**PRELIMINARY PLAN**  
**ROLLIN RIDGE ESTATES**  
EL PASO COUNTY, COLORADO  
**TC & C, LLC**  
17572 COLONIAL PARK DRIVE MONUMENT, CO 80132-2209

ISSUED FOR COUNTY REVIEW	project number
computer file	
issue date	DEC 18, 2017
drawn by	DFJ
checked by	
reference	MAY 2, 2018

sheet number  
**1**  
OF TWO  
P&C PROJECT NO.  
SP-18-001

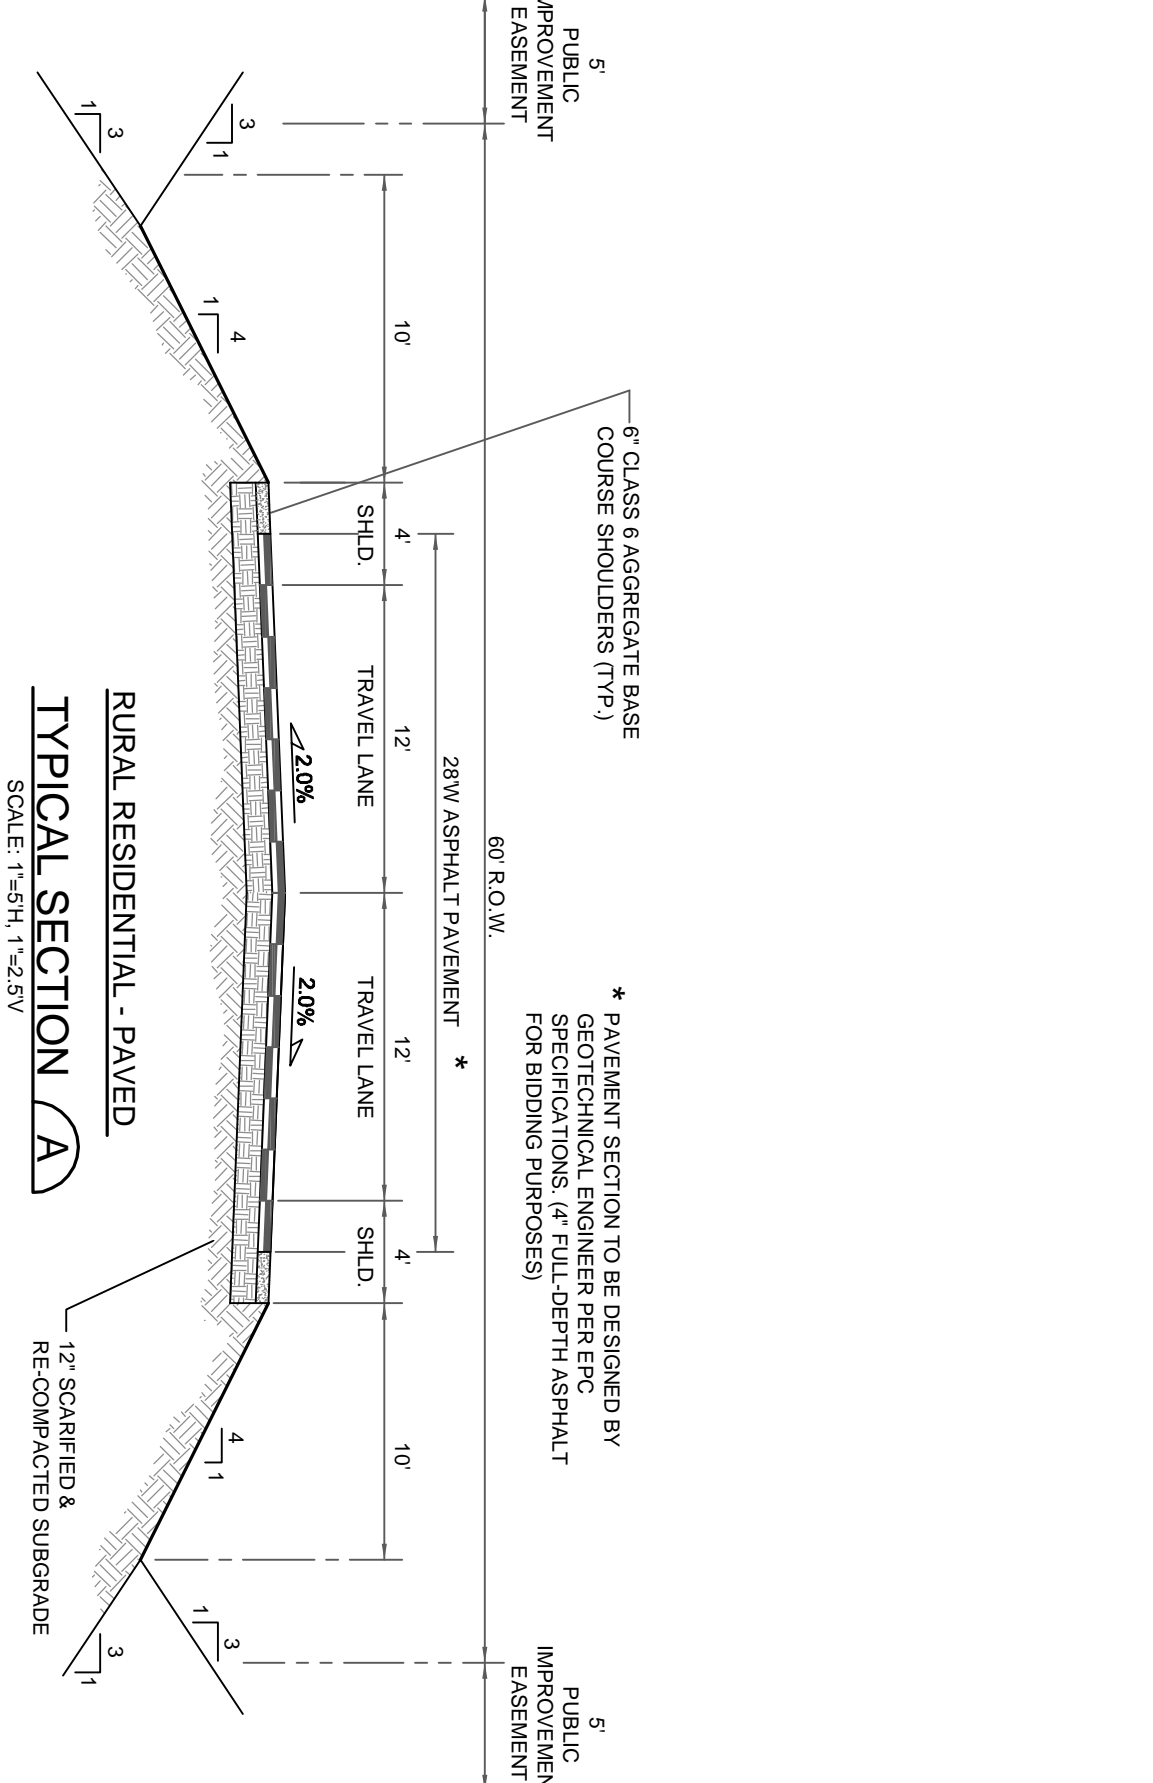
Commercial lot information still has not been provided. Revise Accordingly!

Name of Proposed subdivision needs to be centered on the top of each sheet

Name of Proposed subdivision needs to be centered on the top of each sheet

Commercial lot information still has not been provided. Revise Accordingly

SHEET NUMBER:	2 OF TWO
P&CD PROJECT NO.:	SF18-001

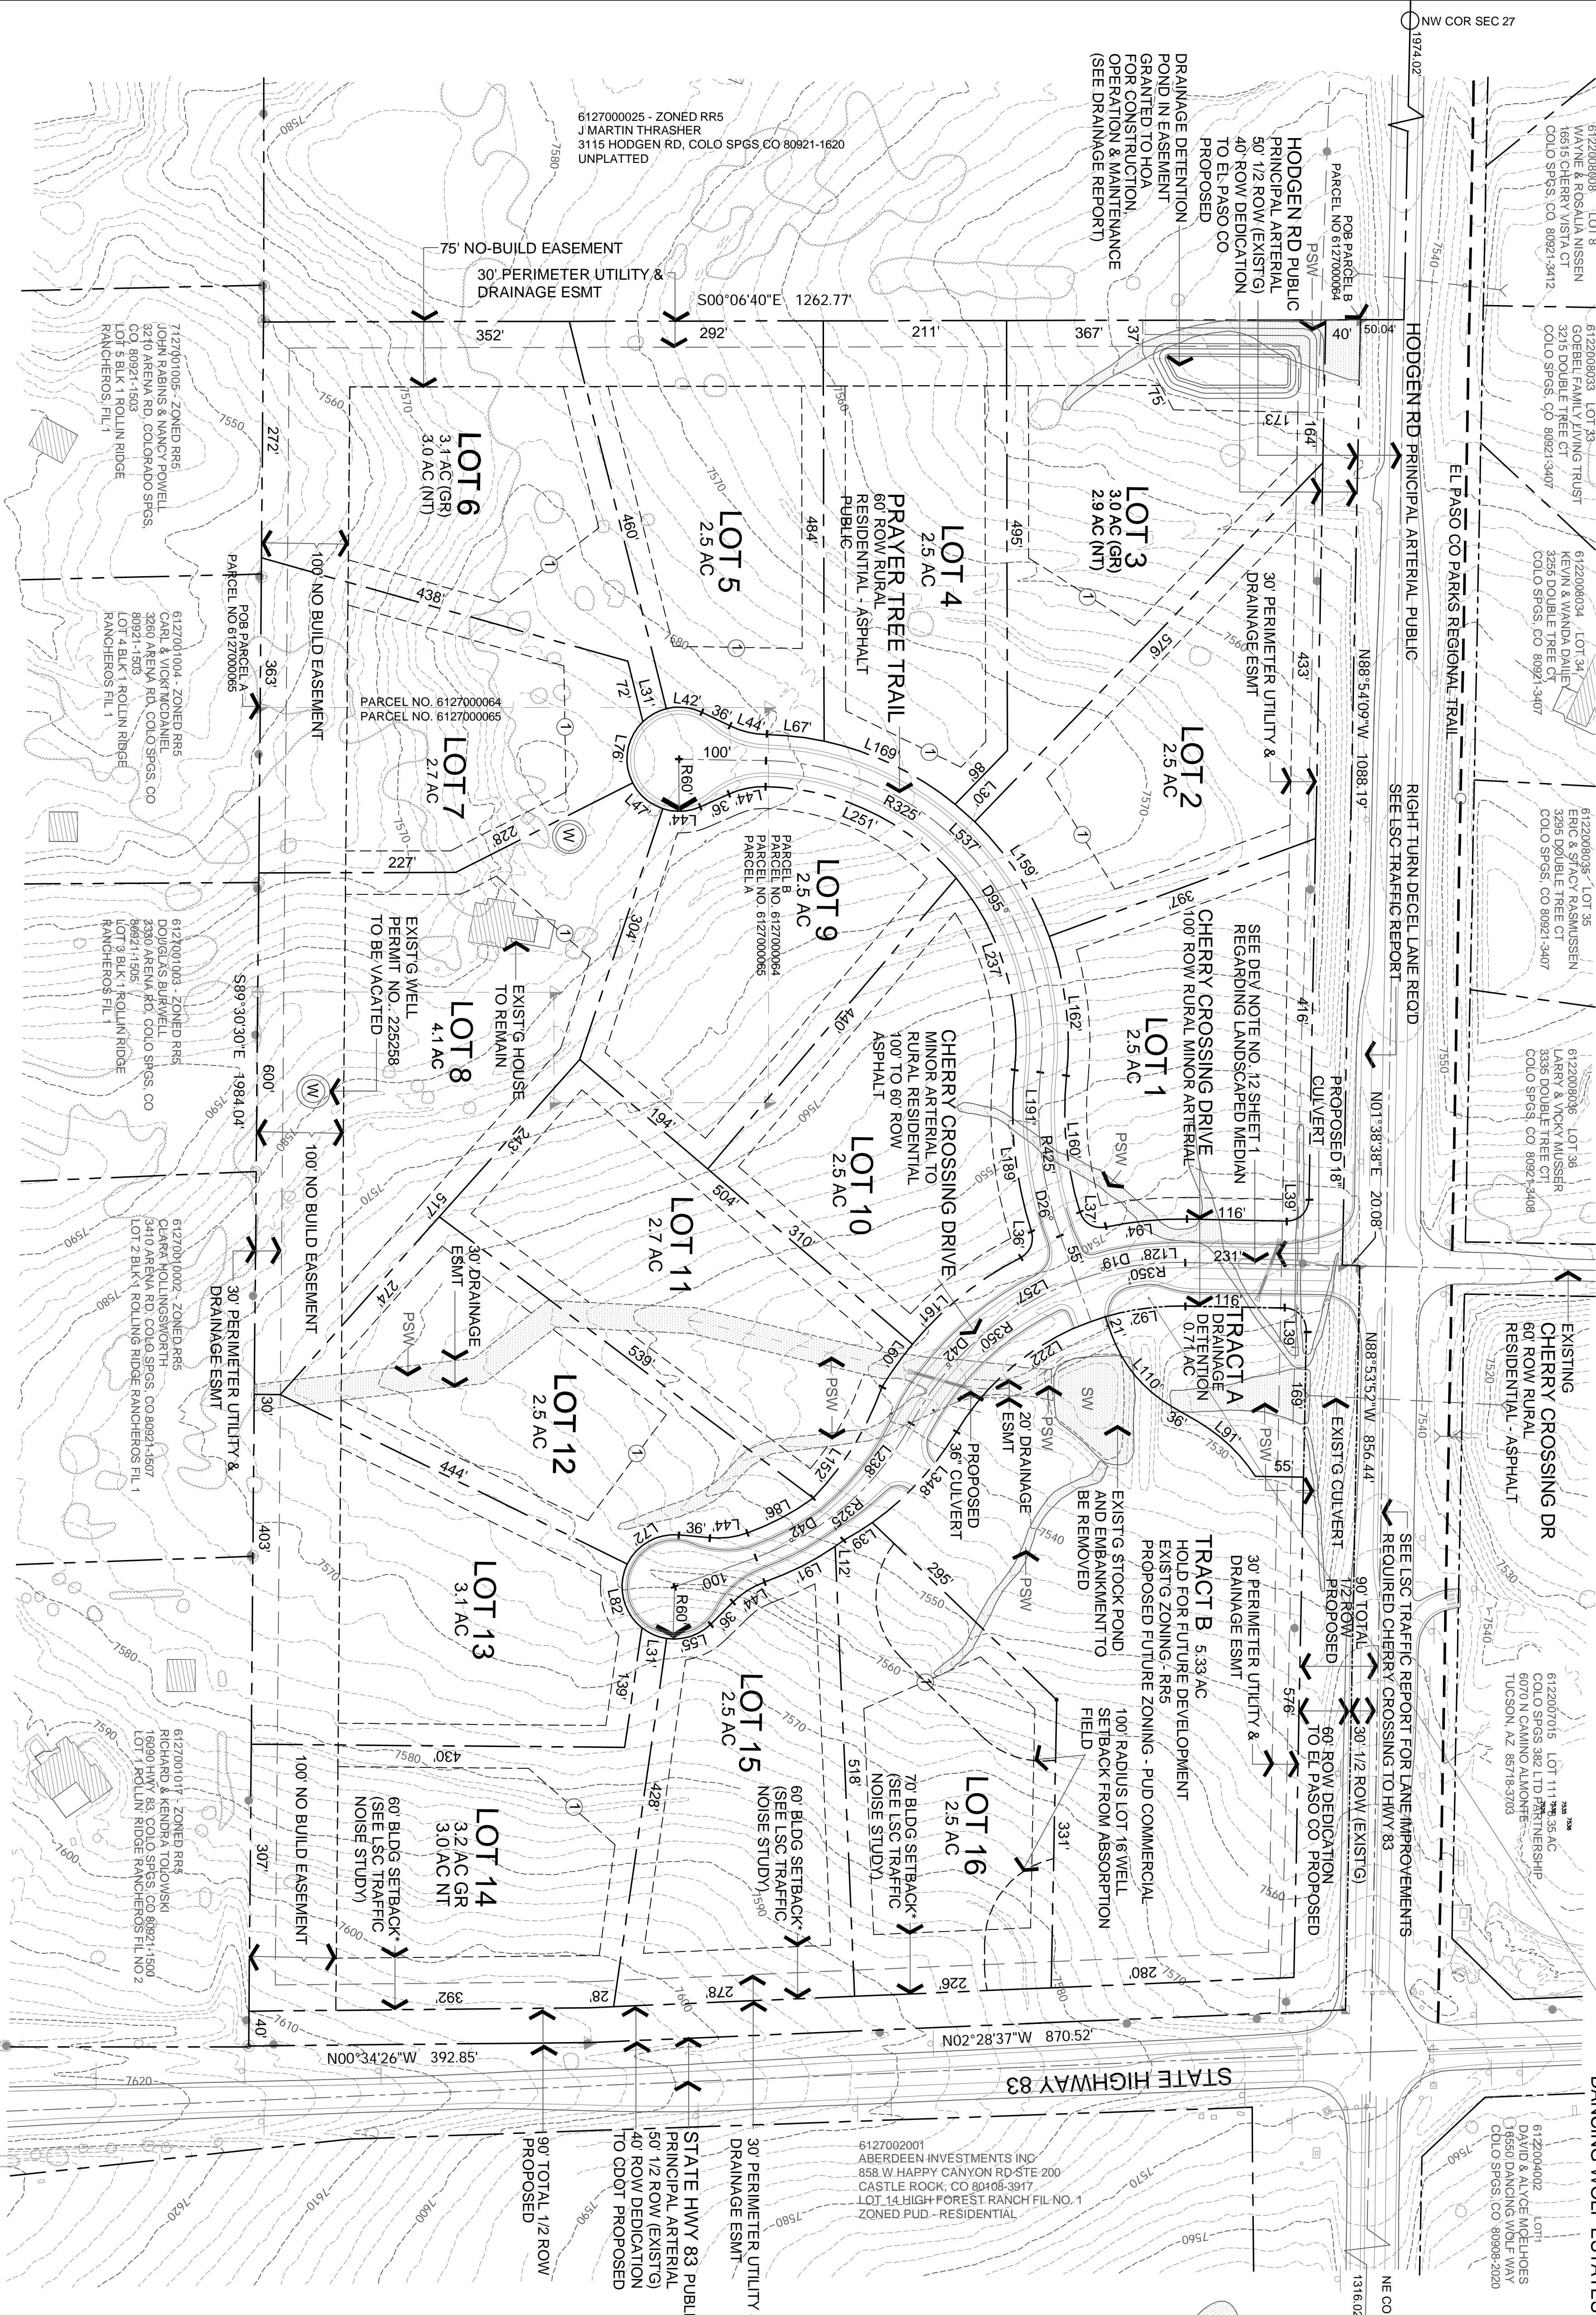
- INDICATES FRONT YARD BUILDING SETBACK AT 200 MIN. LOT WIDTH
- EXISTING STRUCTURES, SHEDS AND OUTBUILDINGS TO REMAIN AT THIS TIME
- NO-BUILD EASEMENT  
Please make sure all hatch patterns are distinctly different.
- INDICATES SOILS THAT ARE POTENTIALLY SEASONALLY WET - SEE ENTECH ENG SOILS & GEOLOGIC HAZARDS REPORT FOR MITIGATION REQUIREMENTS
- INDICATES AREAS OF TREE COVER AND INCREASED LEVELS OF WILDFIRE HAZARDS
- PROPOSED CULVERT - SEE PREL. DRAINAGE PLAN AND REPORT FOR SIZING REQUIREMENTS
- INDICATES SOILS THAT ARE SEASONALLY WET - SEE ENTECH ENG SOILS & GEOLOGIC HAZARDS REPORT FOR MITIGATION REQUIREMENTS
- 25' BUILDING SETBACK (TYP)

Per the provided legend, identify all drainage easements with a hatch.

Please make sure all hatch patterns are distinctly different.

Name of Proposed subdivision needs to be centered on the top of each sheet
